Our Ref: FG/212/18/HH

**Town & Country Planning Act 1990 (as amended)
Town & country Planning (Development Management Procedure) (England) Order 2015
Application for Planning Permission for Works or Extension to a Dwelling**

Development Extension & conversion of existing bungalow including loft conversion with new dormer windows.

Location 30 Ferringham Lane Ferring,,

Client's Name	Drawing Title	Drawn	Date
Mr. & Mrs. R. Brown	Extension and Conversion Of Existing Bungalow	FI/PO/14	26. 11. 18
Job Title	Scale	Status	Rev.
30, Ferringham Lane Ferring West Sussex BN12 5LU	1:50		01

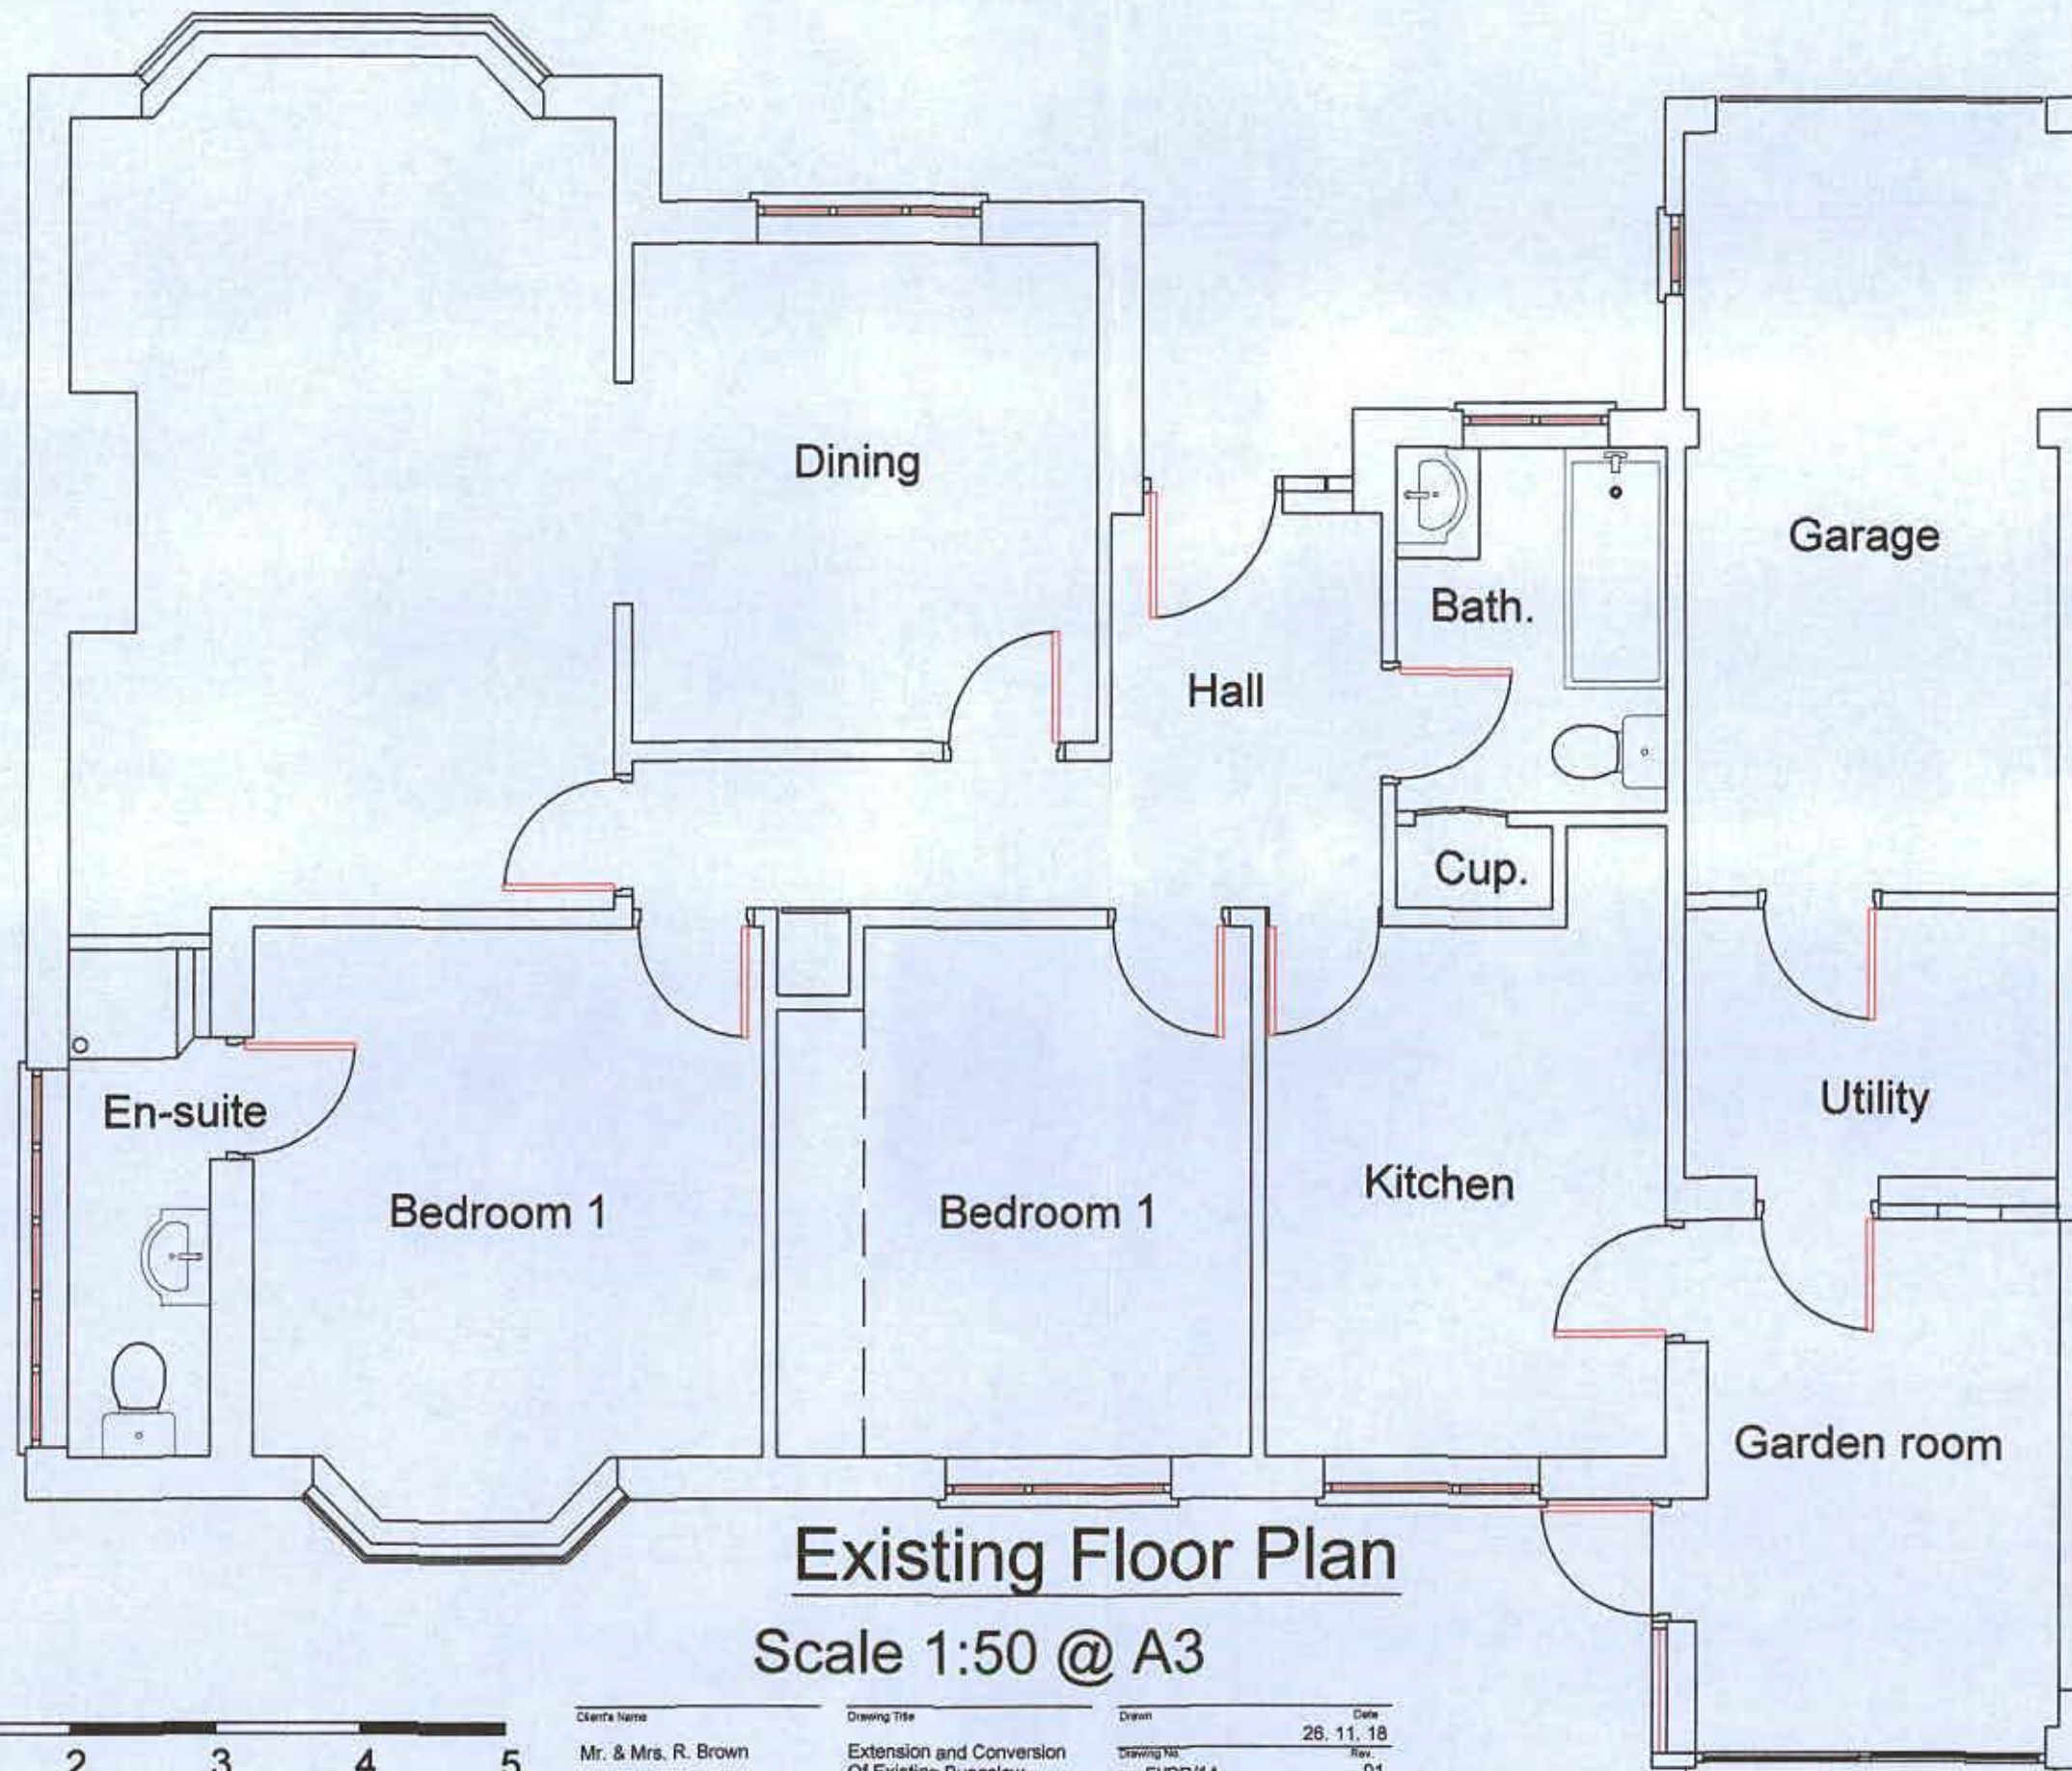
The proposed east elevation does not show the smaller roof light. Please forward amended plans accordingly
